**To:** FILE  
**From:** Jean Fraser  
**Subject:** Application ID: 2014-016  
**Date:** 3/14/2014

**Comments Submitted by: Marge Schmuckal/Zoning on 3/14/2014**

PROJECT PH WARREN AVENUE, LLC
SHEET TITLE SITE LAYOUT AND UTILITY PLAN

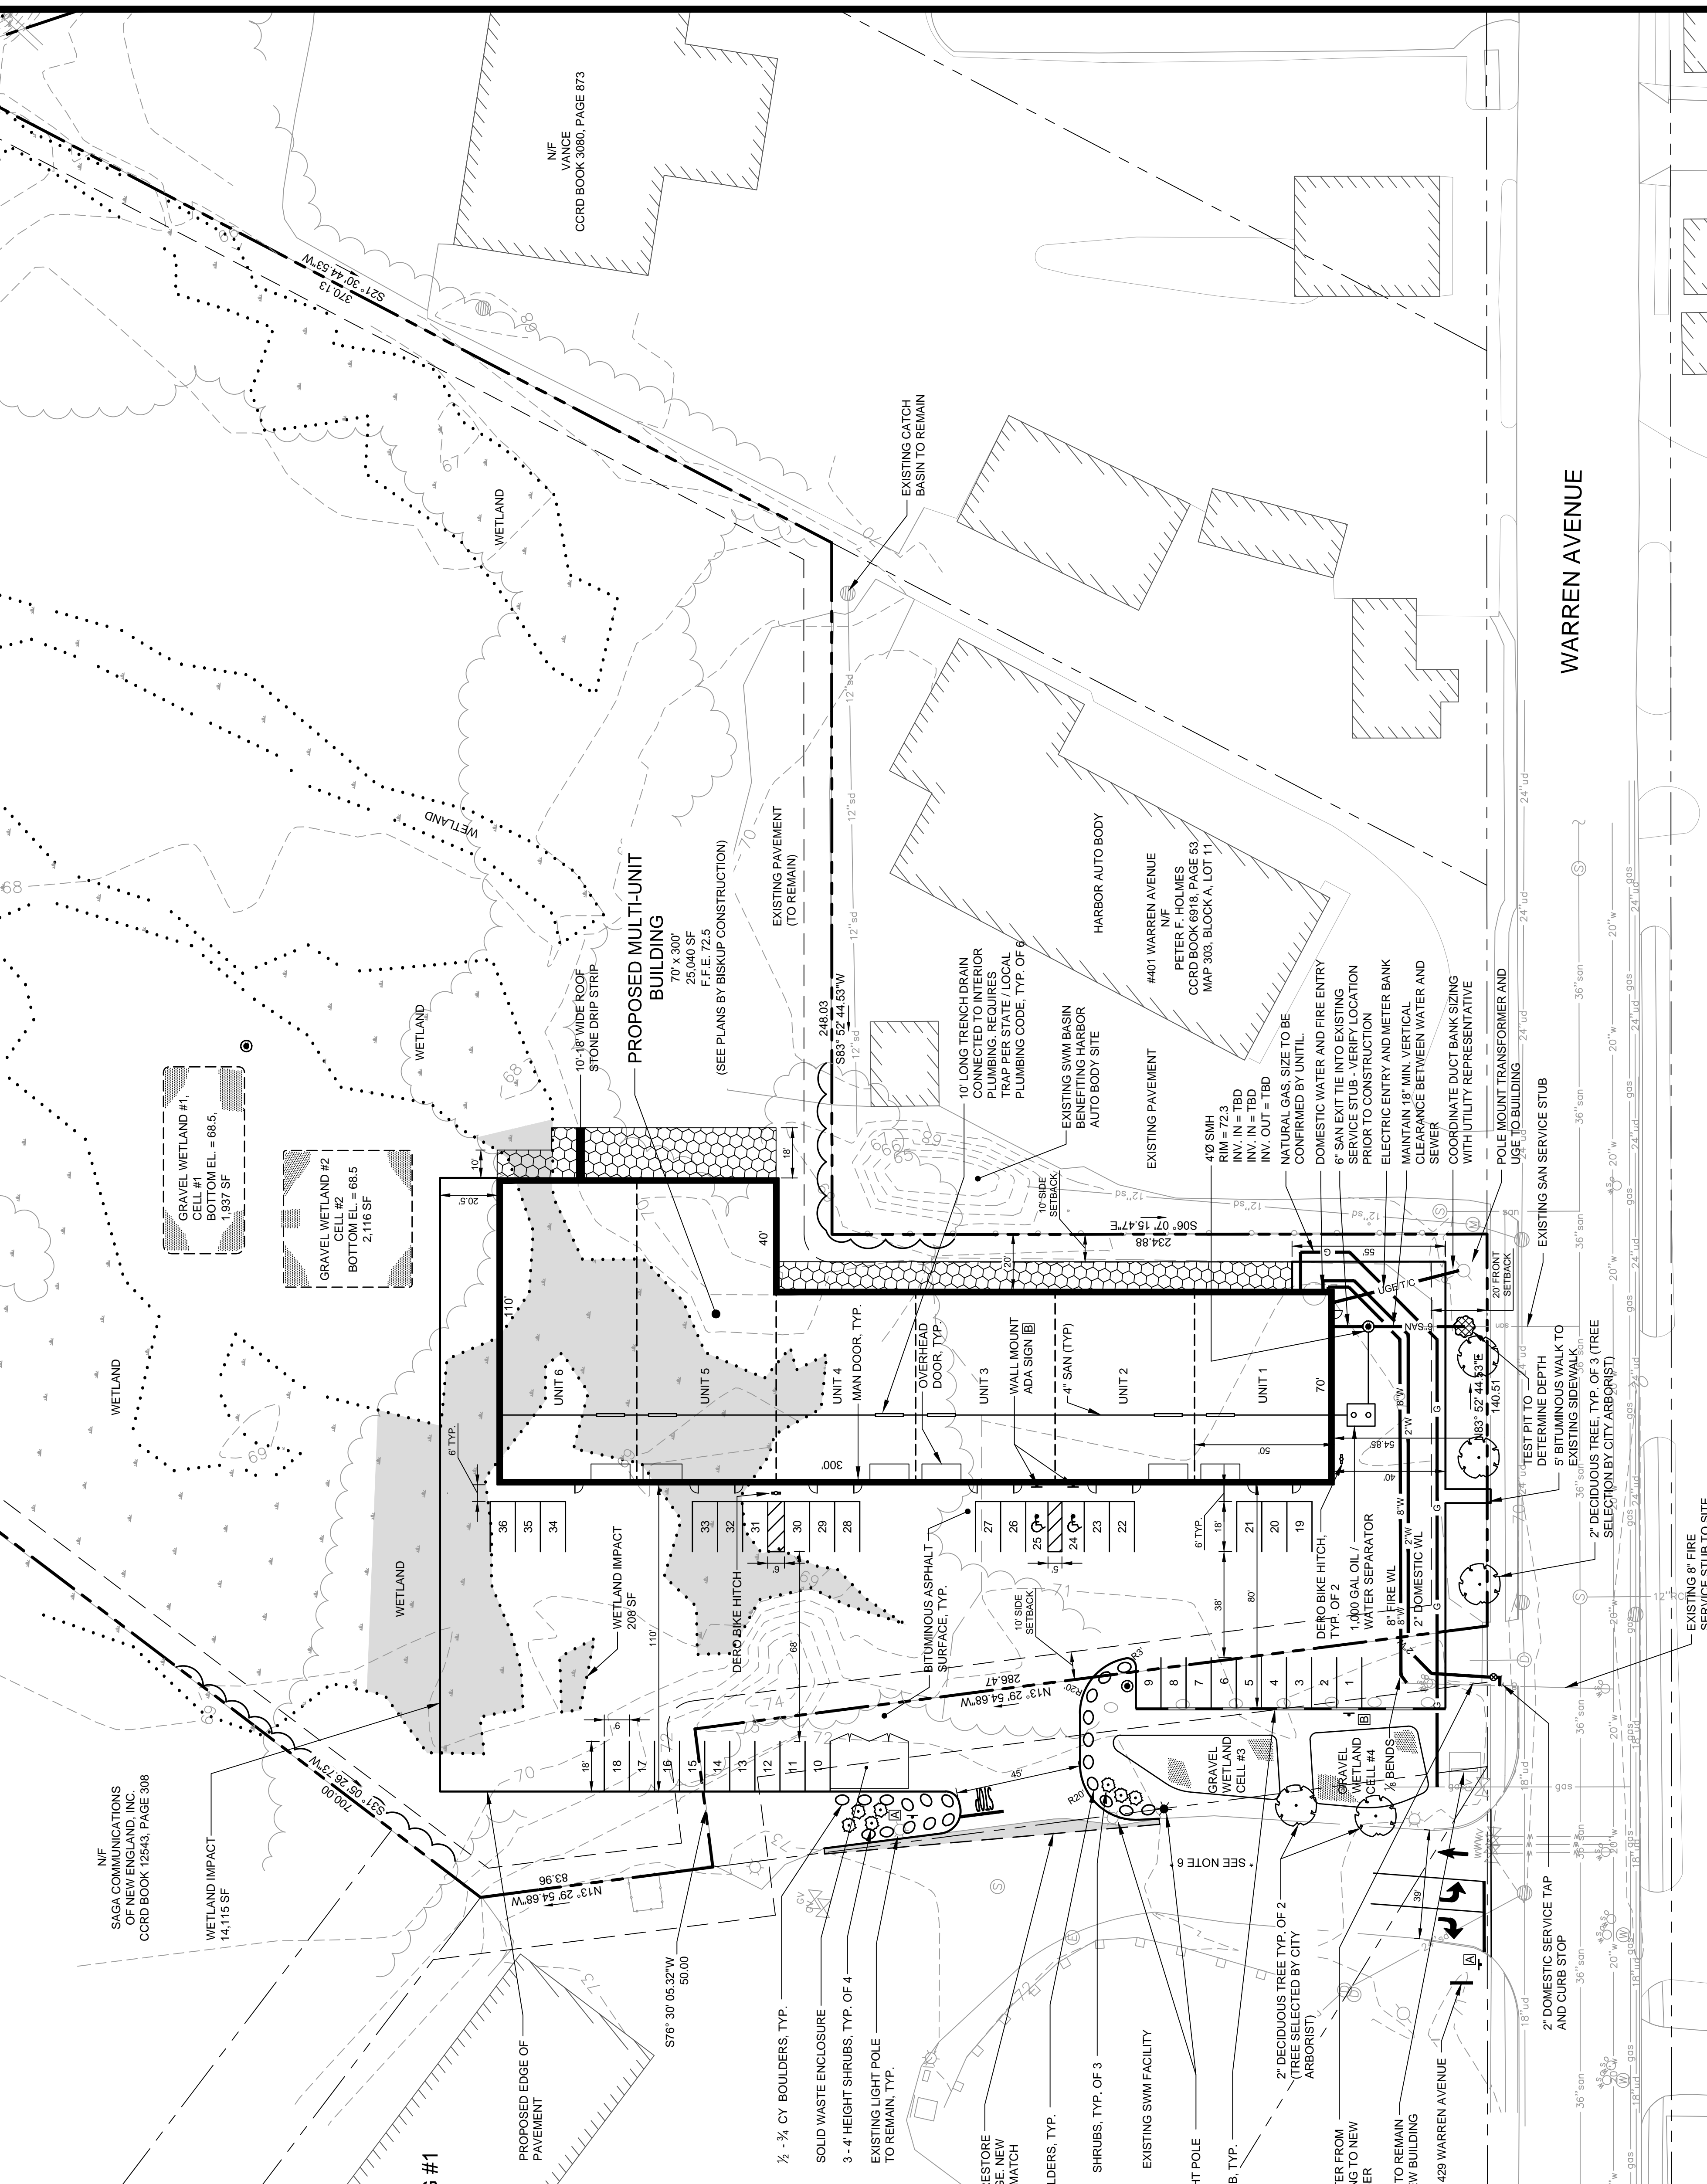
The uses affect the parking requirements. If all the uses are business, manufacturing & industrial uses, then 1 parking space per 1000 sf of floor area is required or 29 parking spaces. 41 parking spaces are shown. I do like that more than the minimum spaces are shown in case a different use is requested later. It gives a good buffer. I also noticed that 14 of the parking spaces are on an adjoining property. Hopefully there are easements that run with the property for those spaces.
